APPLICATION NO: P/18/20/PL

Site Address: Land west of Barton House Manor Park Pagham E2 9LJ

Description of Works: Change of use from highway land to residential use for the development of 4 No. 3 bed terraced houses with associated parking & access. This application affects the setting of a listed building.

Tree Retention Protection Plan

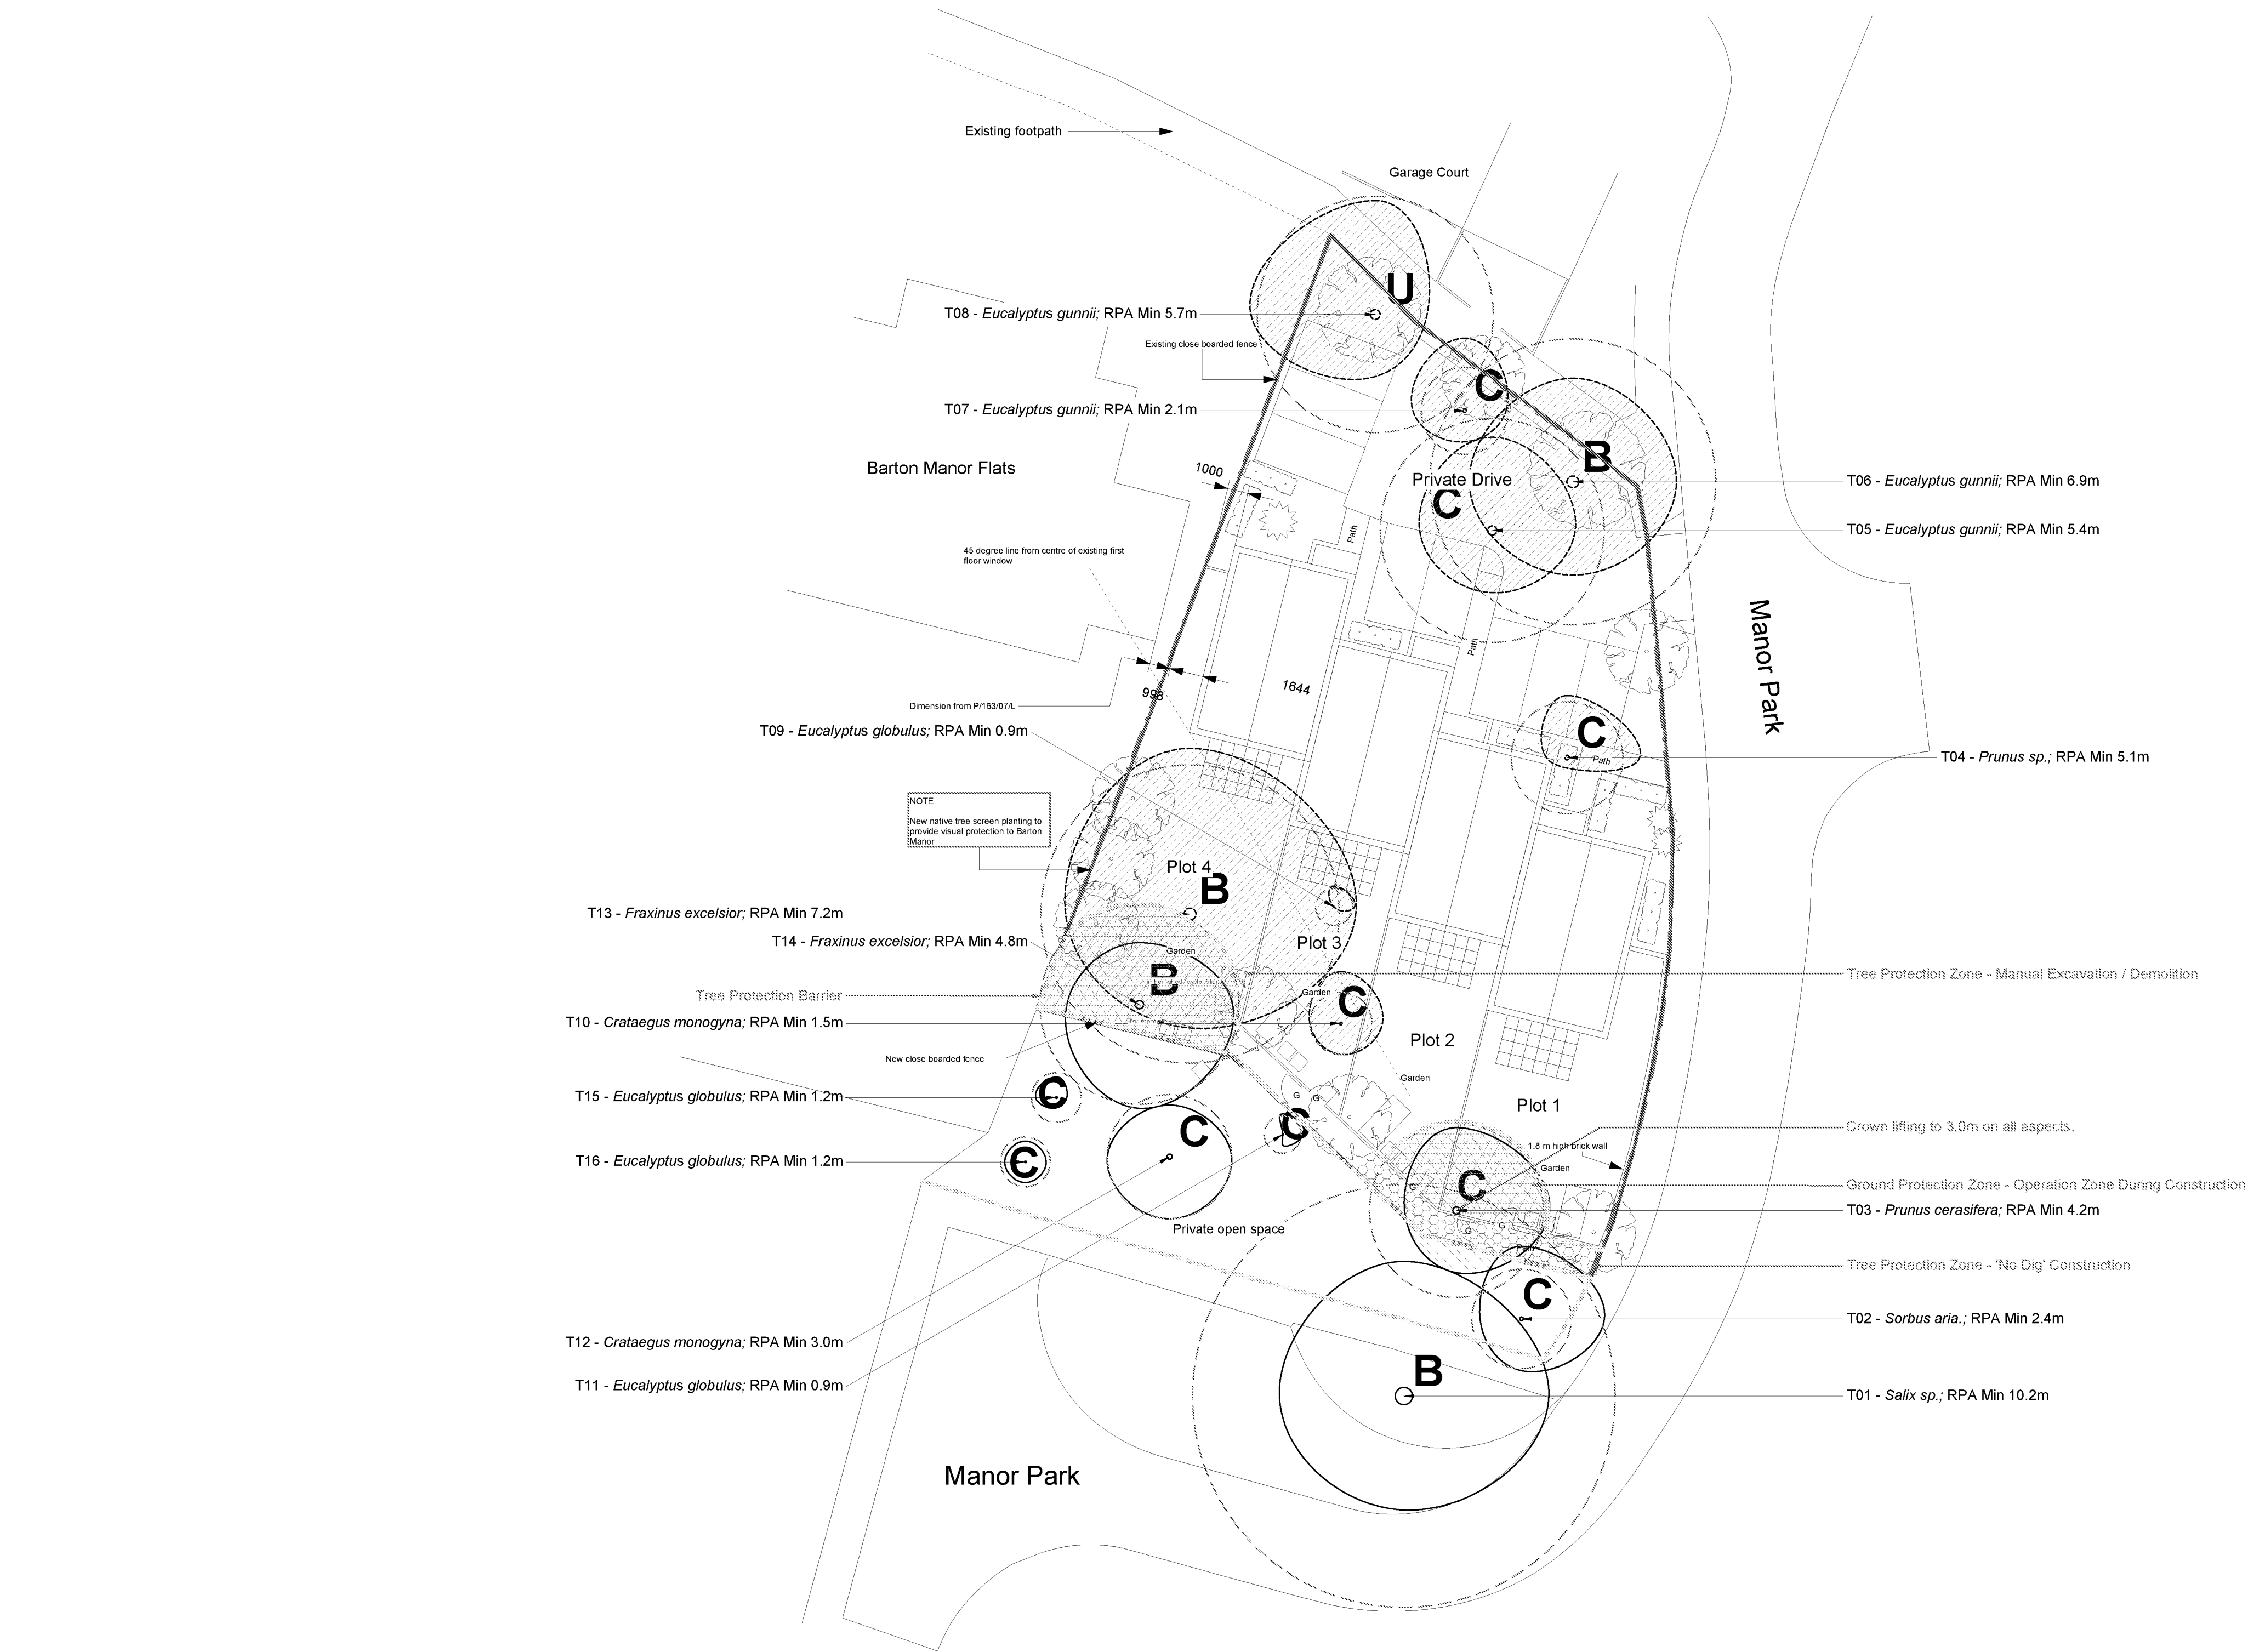
There is moderate potential for bats to be roosting within tree T01 – a willow tree. Current plans show that this tree is being retained, however if this changes further survey work will be required on the tree.
